Planning Application Ref: AW/161/20/HH

Location: 34 Wakefield Way, Aldwick PO21 3RS

Description of works: Two storey side extension

Site Plan

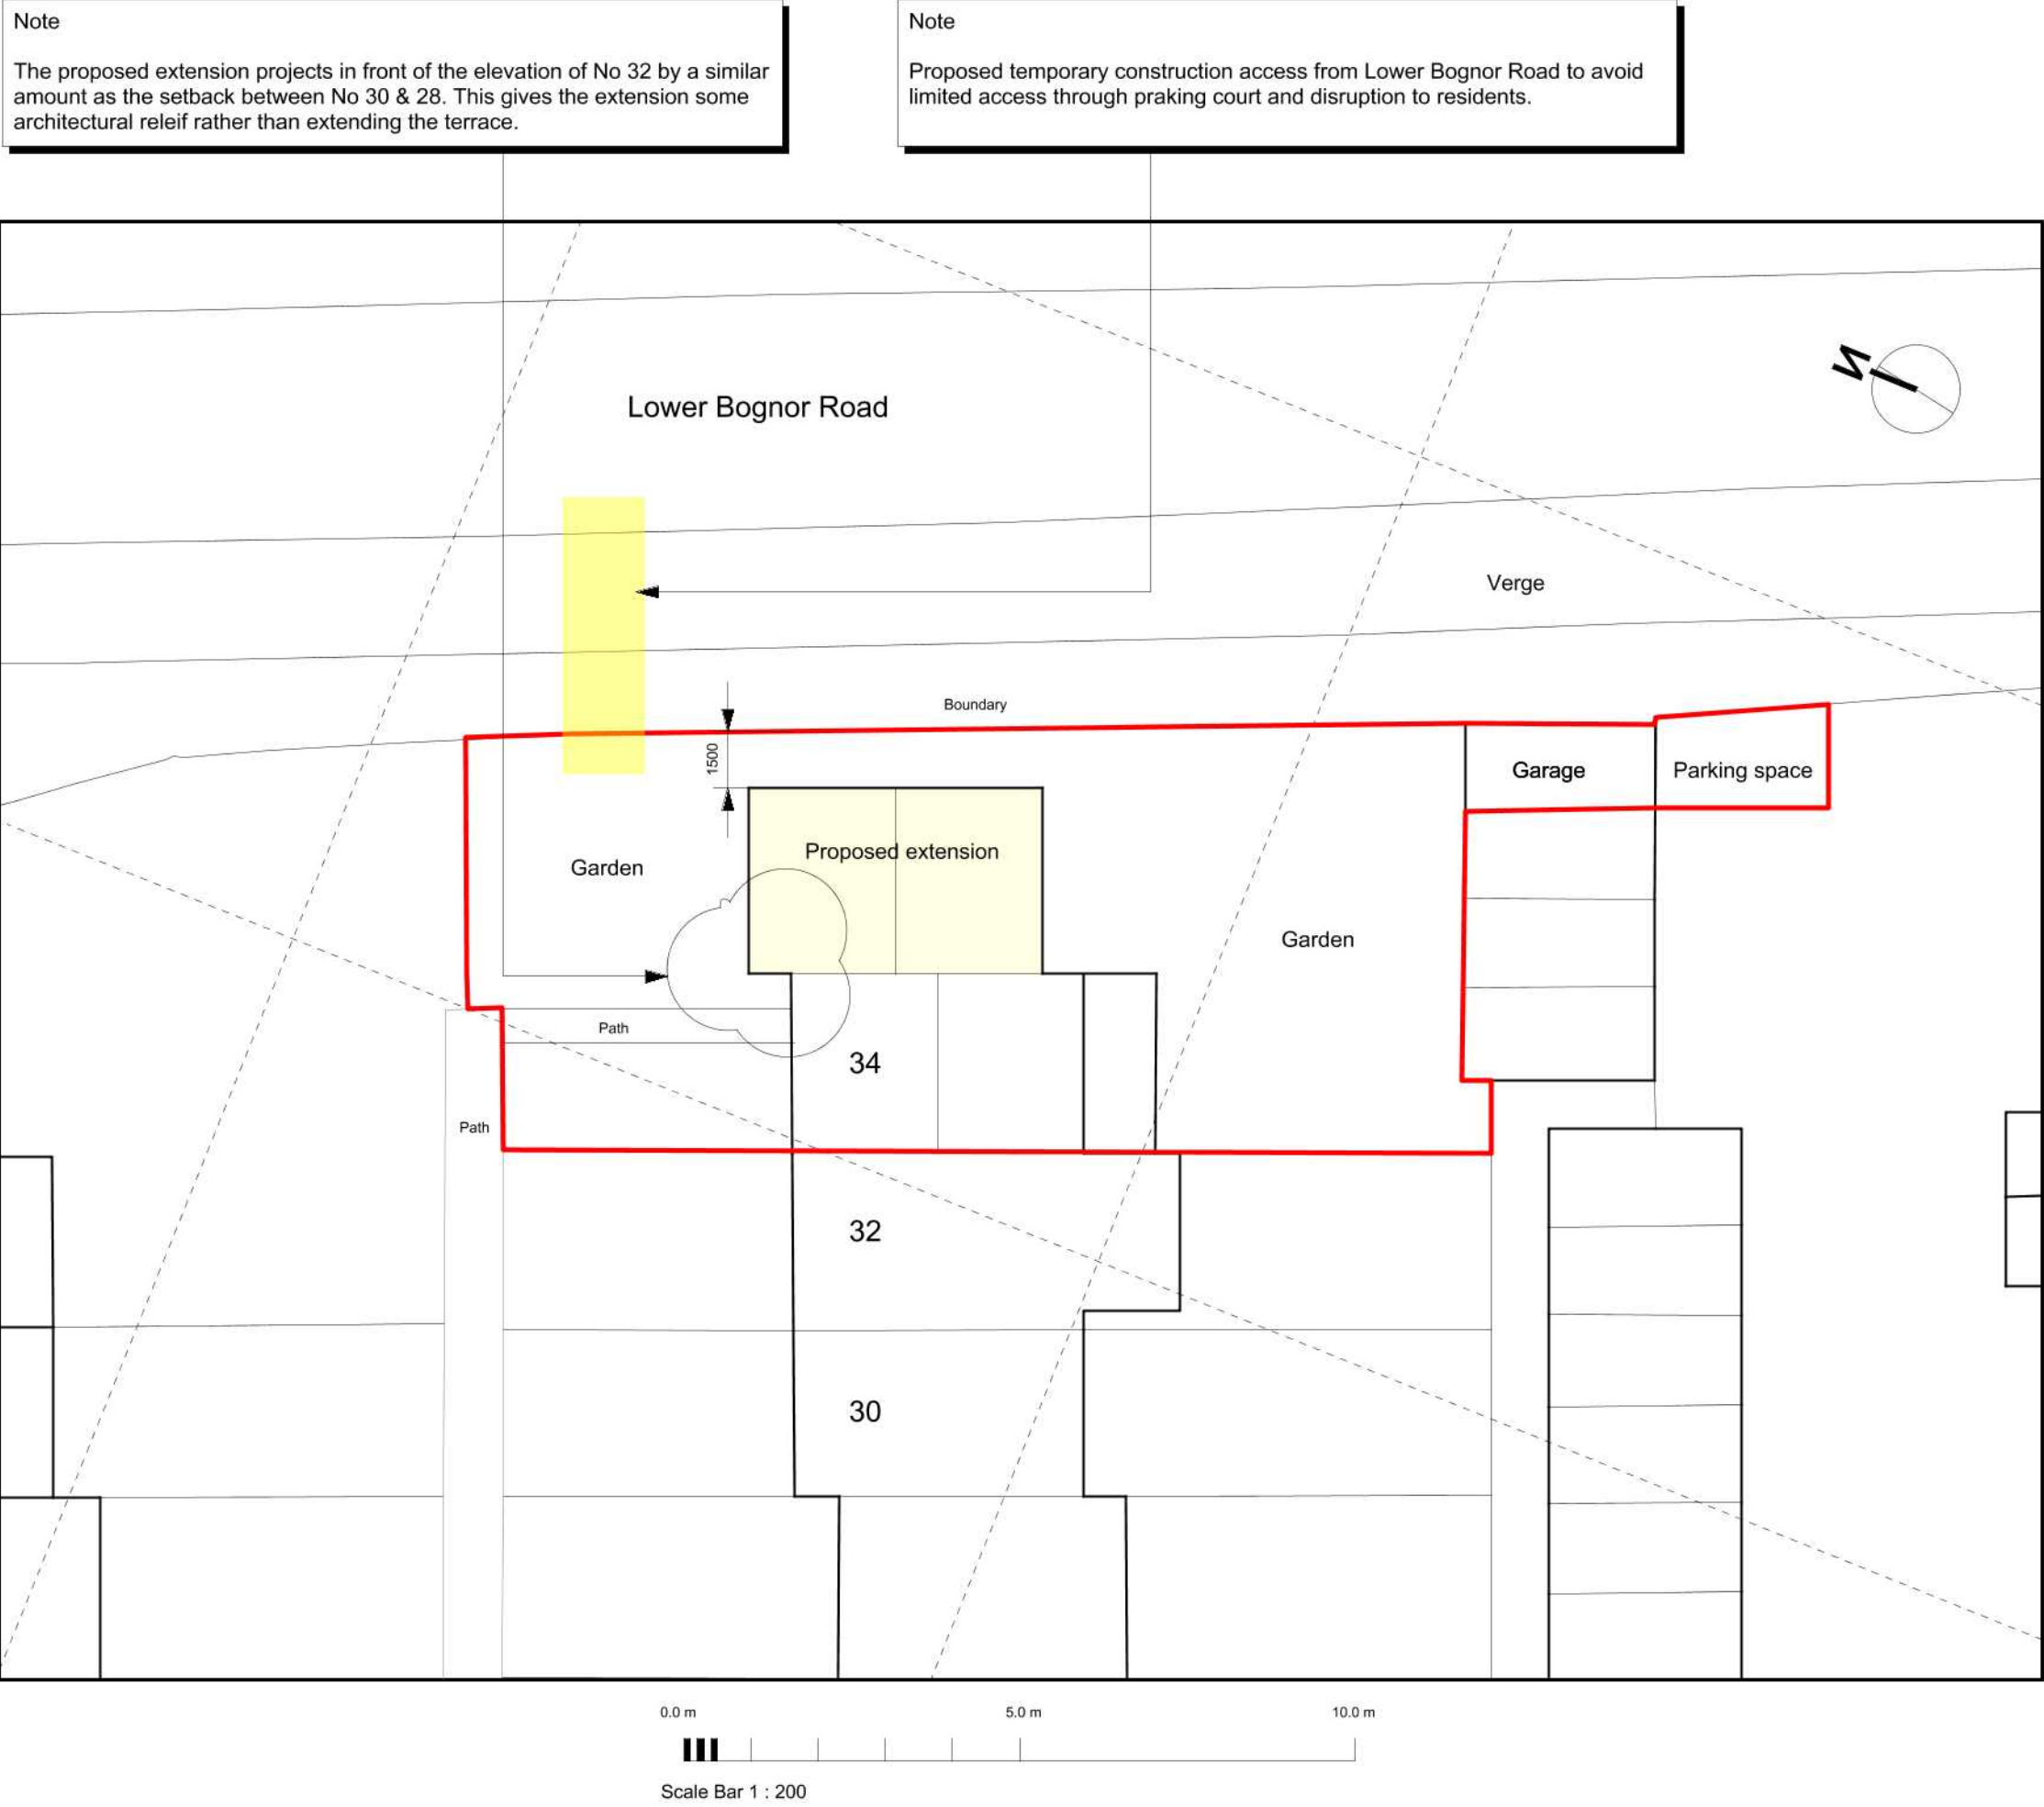
- There is at least one significant tree (an off-site English oak) overlapping the above property and which enjoys statutory protection (Tree Preservation Order). This along with other trees could be adversely affected by this proposal. There is no supporting arboricultural information submitted with the application - a requirement of BS5837:2012. As such, were this application to now proceed, we will not have sufficient information to guarantee such trees would be adequately respected and protected.

- The one large, maturing English oak alongside the property is a major landscape component helping to define the verdant character of the area. This proposal presents a similar footprint to that submitted with previous application AW/246/19/PL (Refused) and which would intrude extensively into that tree's RPA.

- Although we are yet to have sight of the necessary arboricultural reports and plans to demonstrate that on and off-site trees have been properly considered, the likely impact on the most important of those from this proposal is likely to be severe. Whatever engineering/construction methods and above ground protection measures may ultimately be proposed, there is a risk that attaches during such incursion of root protection areas. This is especially significant where the tree in question is one of the most important locally.

- I recommend **REFUSAL** for this scheme.
